Kirklees Planning and Development

Planning application number 2025/62/93126/W

The Coach & Horses, Eastgate, Honley, Holmfirth, HD9 6PA

Please accept this letter as our formal objection to the above referenced planning application to turn the former Coach and Horses public house into apartments.

4 Proposed Site Area  
 1 : 200

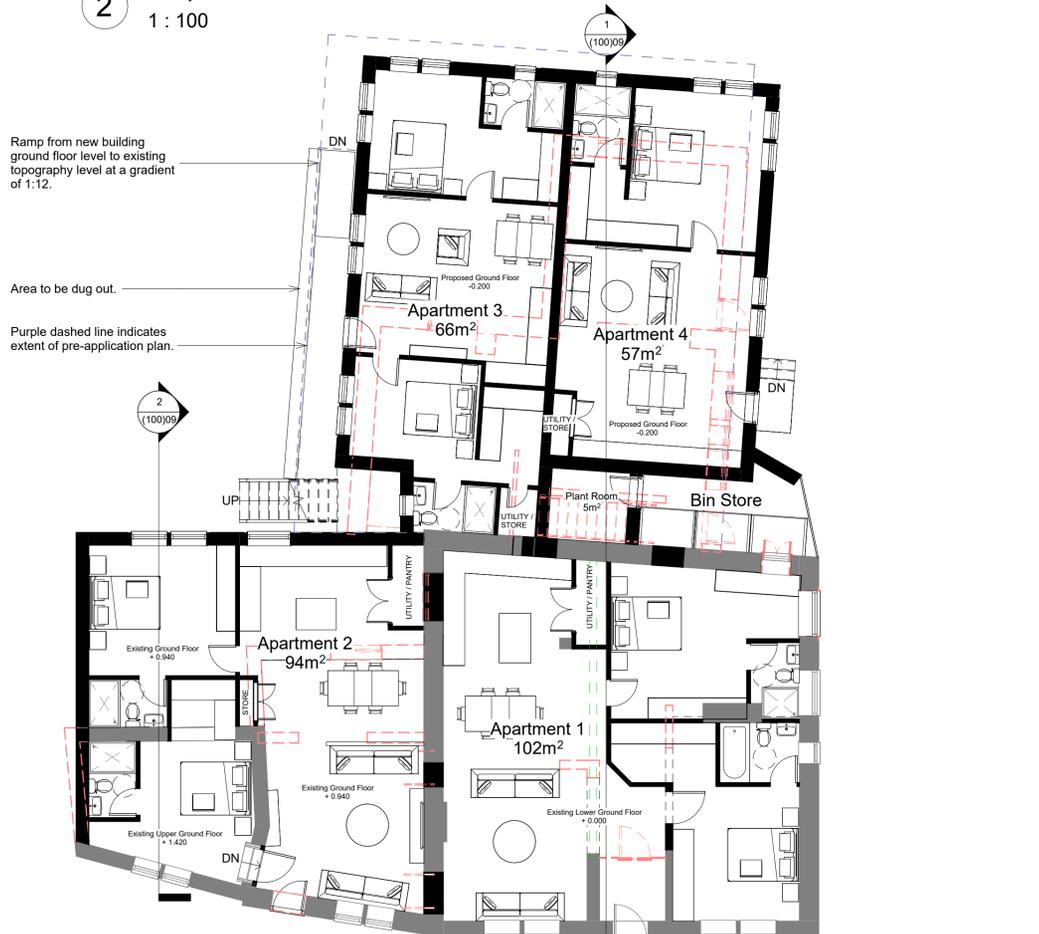
The proposed on site parking, 12 individual parking bays, could be argued as insufficient in relation to the 9 apartments; how and where is the overspill to be accommodated. River Park must not become a car park.

The inclusion of an elevated patio fronting onto and over opposite and adjacent residential properties is of further concern when considering the potential for unwanted noise and light pollution.

1 North-East Facing Elevation
1 : 50

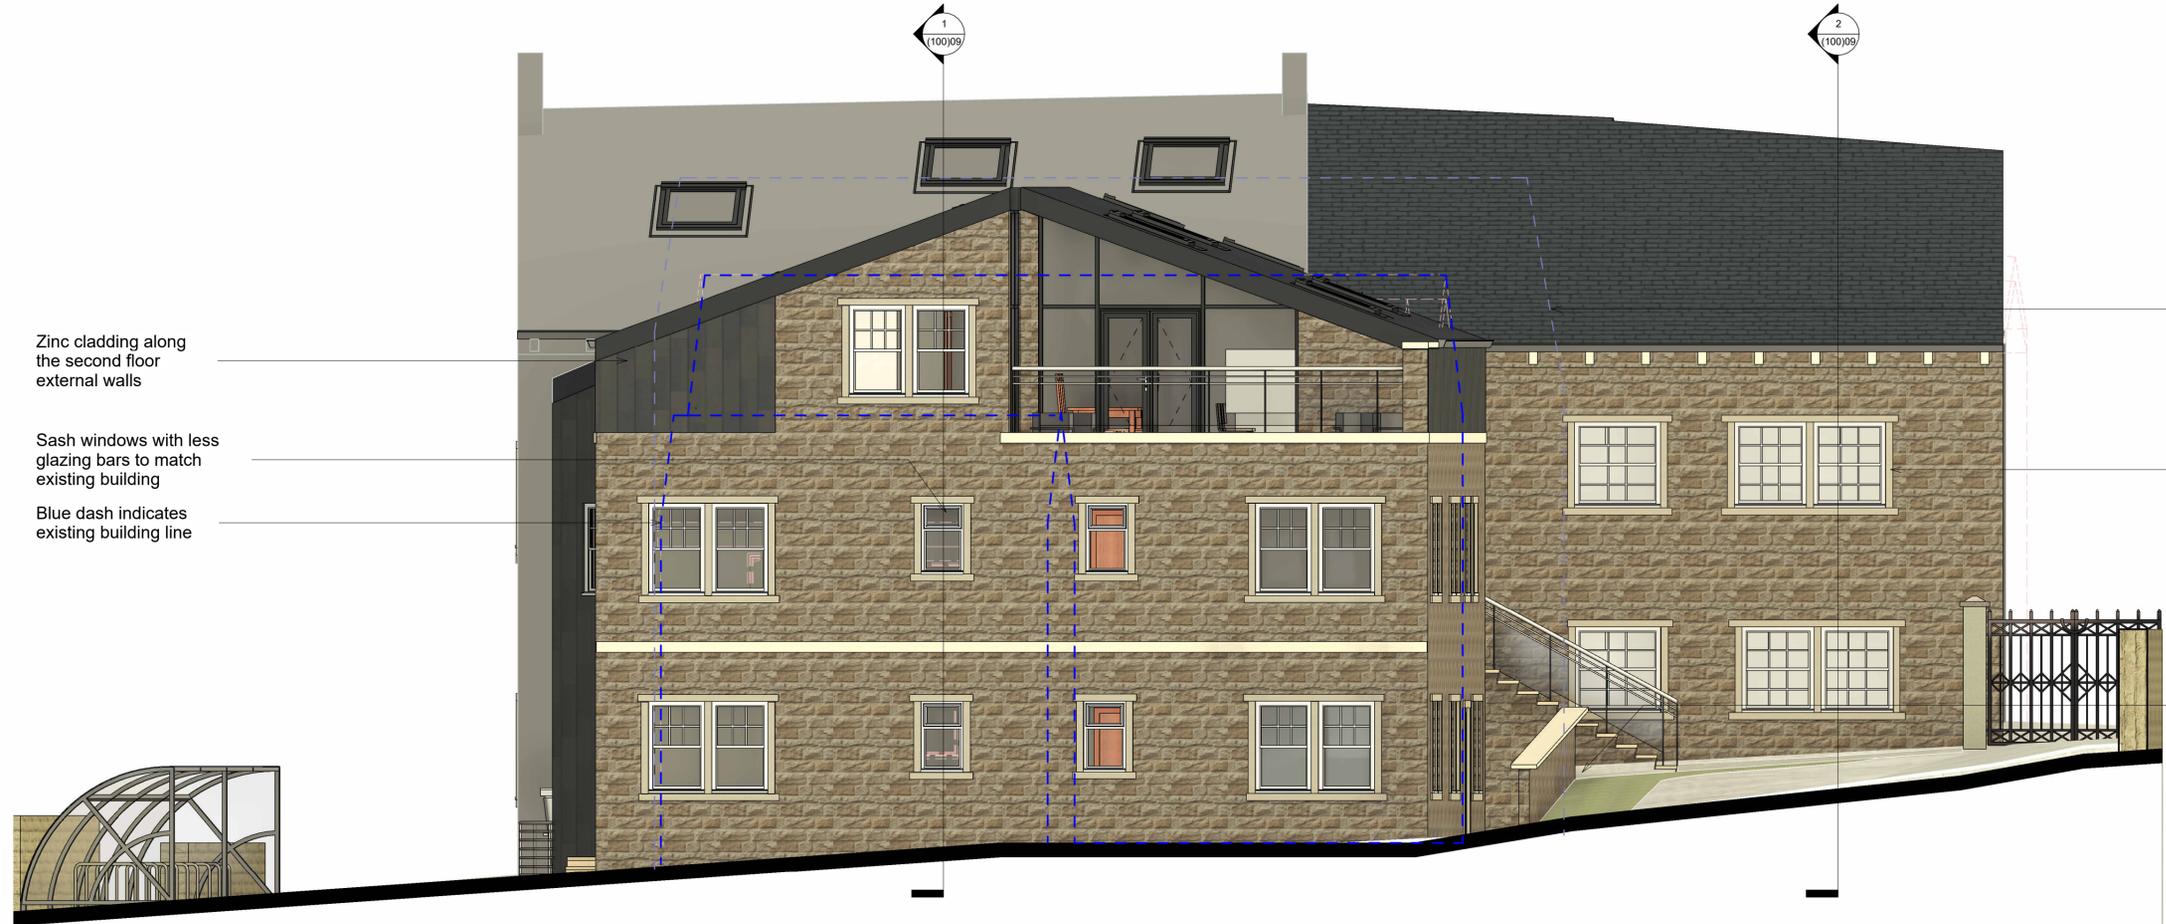
The scheme may communicate conformity with planning guidance on distance and angles between habitable rooms of adjacent residential property; there is however the intimidating scale.

The sheer scale is conceivably just as much of an infringement on privacy.

The drawings are not constant in communicating the various facets of the building's facade, with elements drawn as representing one material while being annotated as another.

There is an element of loss of context. The elevation drawings do point out the designers previous, assumed, pre planning submission of the scheme, highlighting their earlier proposed silhouette. This is irrelevant and should not be given credit for betterment in scale or pre planning consultation.

The true reference line, which is lost in the drawing and without being referenced, is the silhouette of the existing building.
